Subject: RE: Application WA/93/20/PL - Tye Lane, Walberton, BN18 0LU - Alternative access & emergency access along with minor highway works following WA/95/18/RES. This site is in CIL Zone 2 (Zero Rated) as other development.

Site: Tye Lane, Walberton, BN18 0LU

Proposal: Alternative access & emergency access along with minor highway works following WA/95/18/RES. This site is in CIL Zone 2 (Zero Rated) as other development.

Highways England's Reference: 89941 #12039

Figure 9: PIA Data – A27/A29 Fontwell West Roundabout (Source: WSCC Safer Roads Partnership)

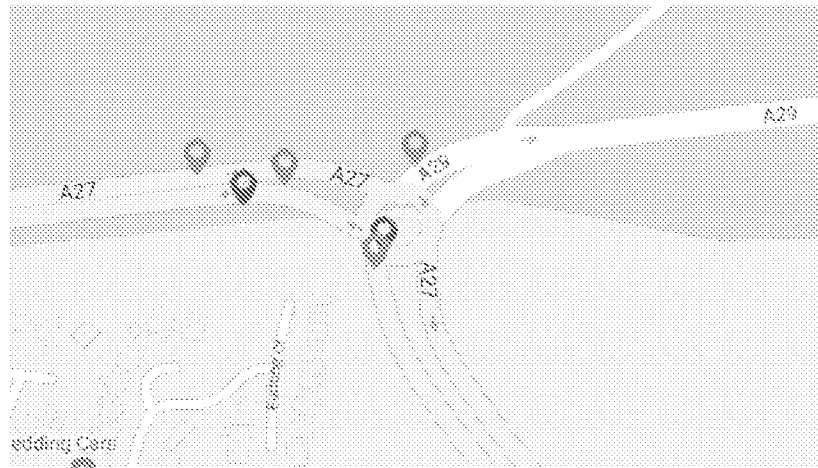
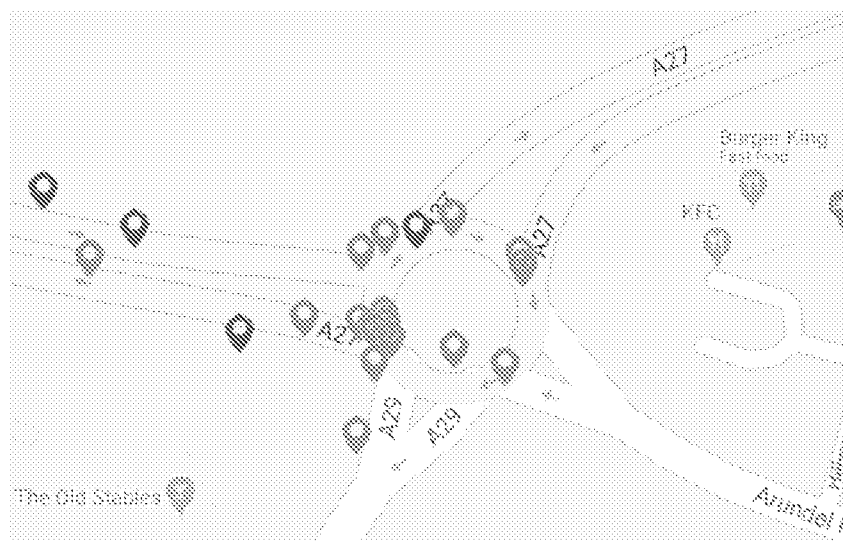
- 6.5 – please note that HE does not accept % increase assessments particularly where the network is already at or over capacity.
- 6.20 – we note from paragraph 5.6 that the site itself has been excluded from the committed developments, except for the 30 additional dwellings, while paragraph 6.20 outlines that the LINSIG is based on the Land East of Tye Lane mitigation layout in Appendix E. As such, this layout is not appropriate for the “2031 Base” and “2031 Base + Committed Development” scenarios, which should be updated to be based on the Local Plan mitigation scheme.

- 6.27 – Highways England does not recognise the purpose of the “Base + Development Trips” scenario, nor its comparison with the “2031 Base” scenario. To determine the impact of the development, comparison should be between the “2031 Base + Committed Development” and “2031 Base + Committed Development + Development” scenarios, and therefore, the revised assessment should consider comparison of these scenarios.

- Notwithstanding the above, the modelling presented shows that the A27 Westbound arm is overcapacity in the “2031 Base + Committed Development” and “2031 Base + Committed Development + Development” scenarios in the PM peak with the latter showing a detrimental impact as a result of the development, yet no mitigation is proposed. Please note that where an arm is operating overcapacity and a development has a detrimental impact, it will be required to provide mitigation to ensure that it has a nil detriment impact, and therefore, if the revised assessment shows this, mitigation should be proposed to ensure a nil detriment impact.
